**Your Ref: 2025/1000
Our Ref: A/03231**

17th March 2026

The Crescent, Cudworth, Barnsley, S72 8SY - (BARNS) - Proposed demolition of existing commercial/residential buildings and creation of new urban park to provide public open space and associated works

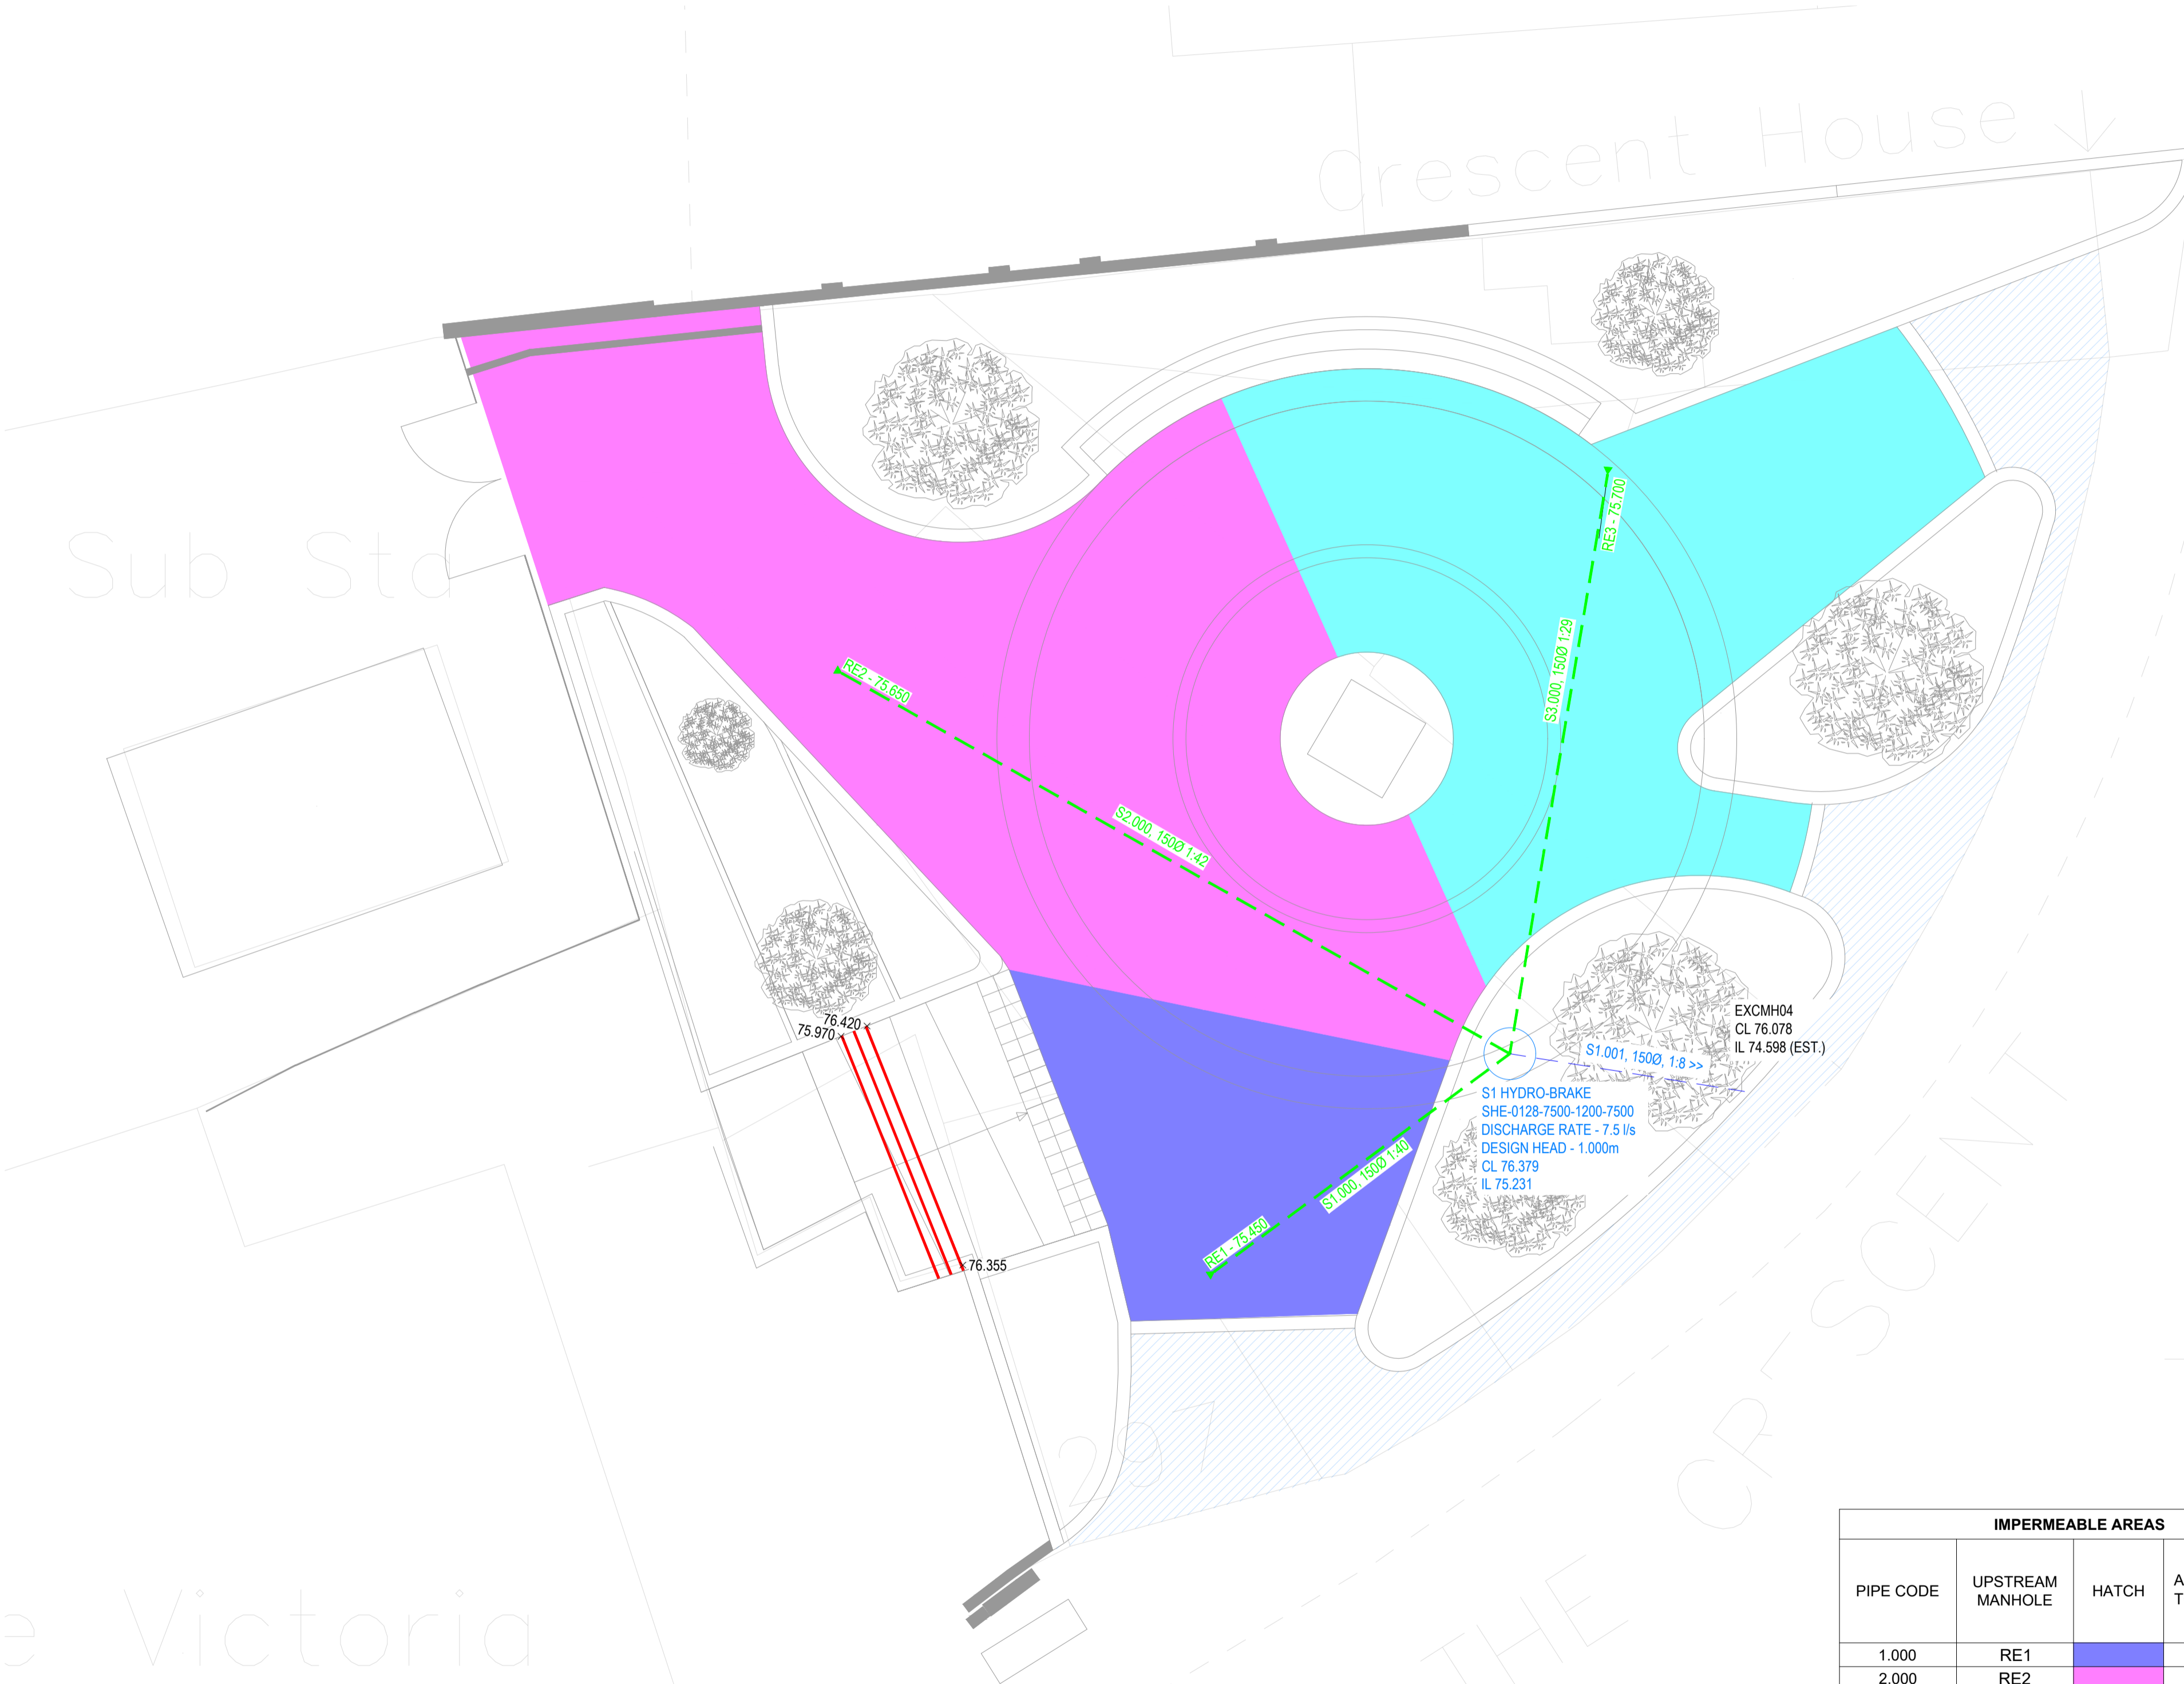
d.) The means of surface water management has not been properly considered within the FRA/drainage report. Yorkshire Water requires further information regarding the means of draining surface water from the development

3.) On the Statutory Sewer Map, there is a small diameter public combined water sewer recorded to cross the site. It is essential that the presence of this infrastructure is taken into account in the design of the scheme.

a.) It may not be acceptable to raise or lower ground levels over the sewer and we will not accept any inspection chambers on the sewer to be built over.

b.) In this instance, Yorkshire Water would look for this matter to be controlled (by Requirement H4 of the Building Regulations 2010).
